Landscape Response to EIA Scoping Request

**Ribble Valley Borough Council Planning
Application 3/2019/0977**

**EIA Scoping request for the installation of tunnelled pipework at the Bowland
Section of the Haweswater Aqueduct and associated works**

26th November 2019

FIGURE 3.2

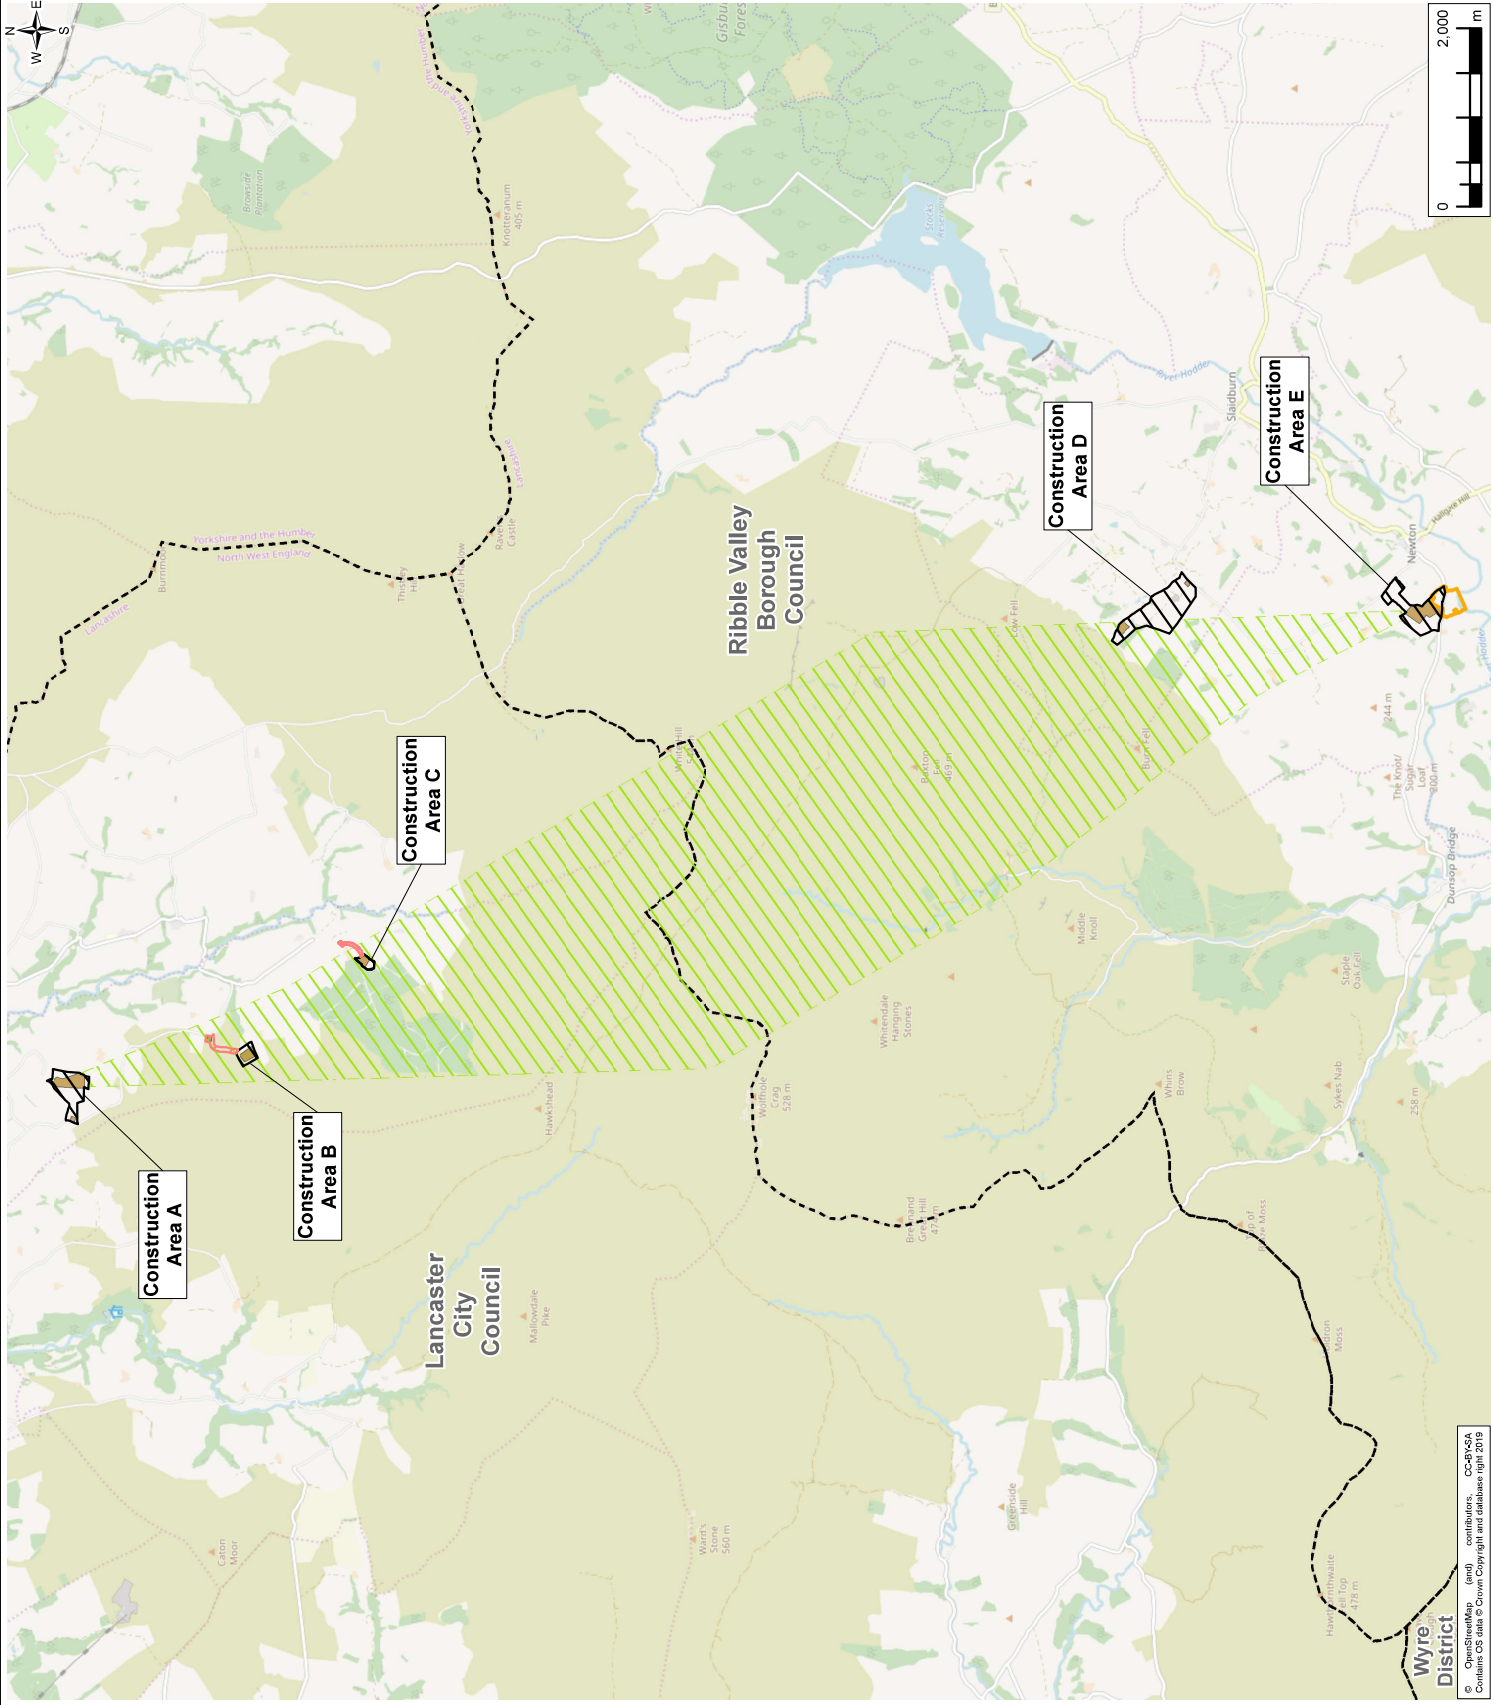
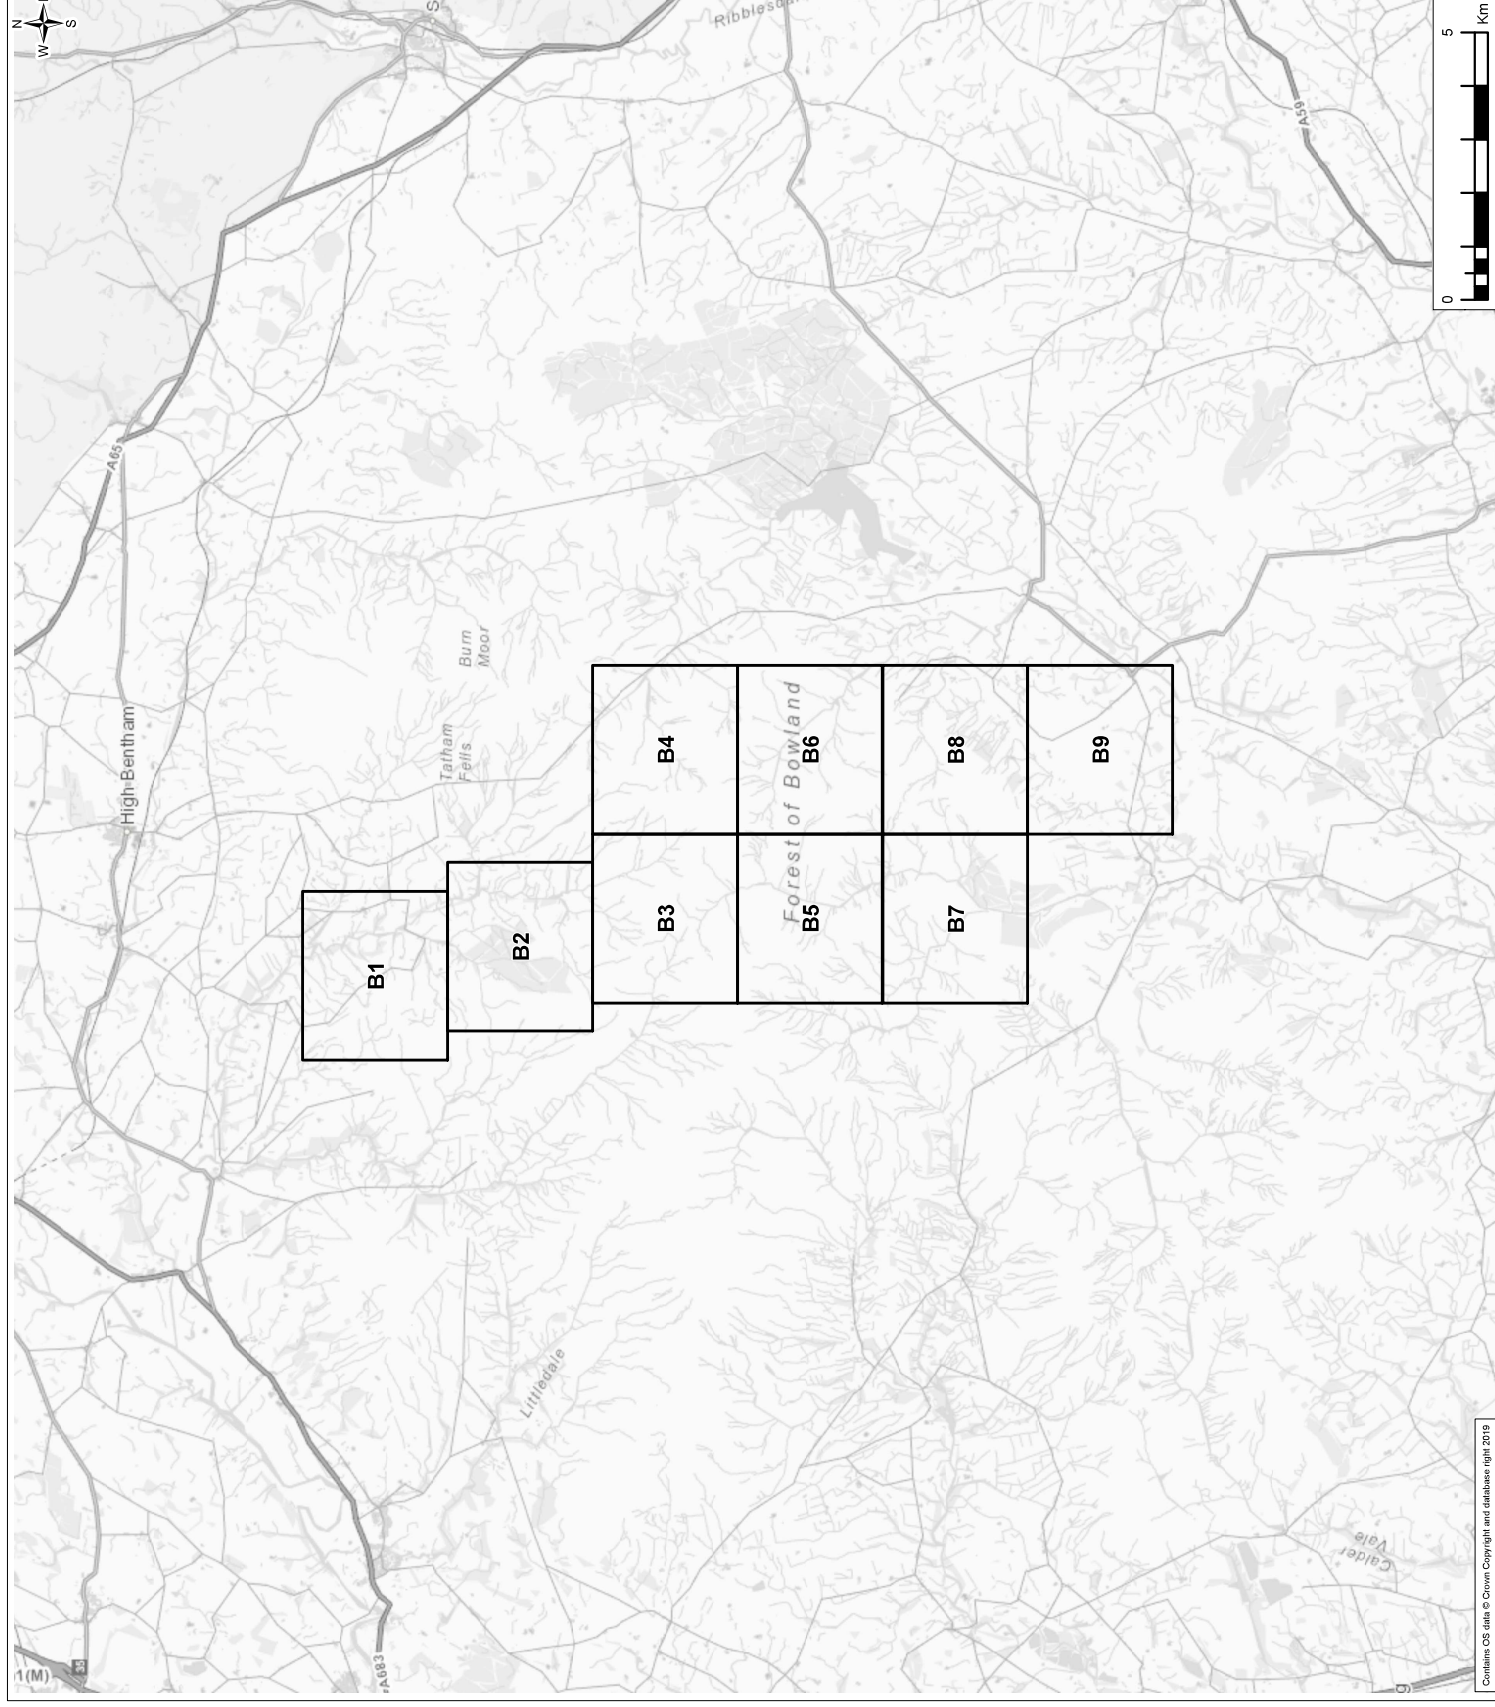
Considering the stage at which the Haweswater Aqueduct project is at, the construction areas seem to be relatively accurately depicted on the figures submitted with the scoping report, e.g. Figure 3.1, B1, B2, etc. Usually a scoping report would show possible locations for these elements of the proposals as very basic graphic symbols generally located in a broad search area. This would be supported with a description of the options selection process used to determine the final location of the construction site. The precision of the construction area's boundary lines on the various figures suggests that these are the actual rather than indicative locations for these elements of the final scheme.
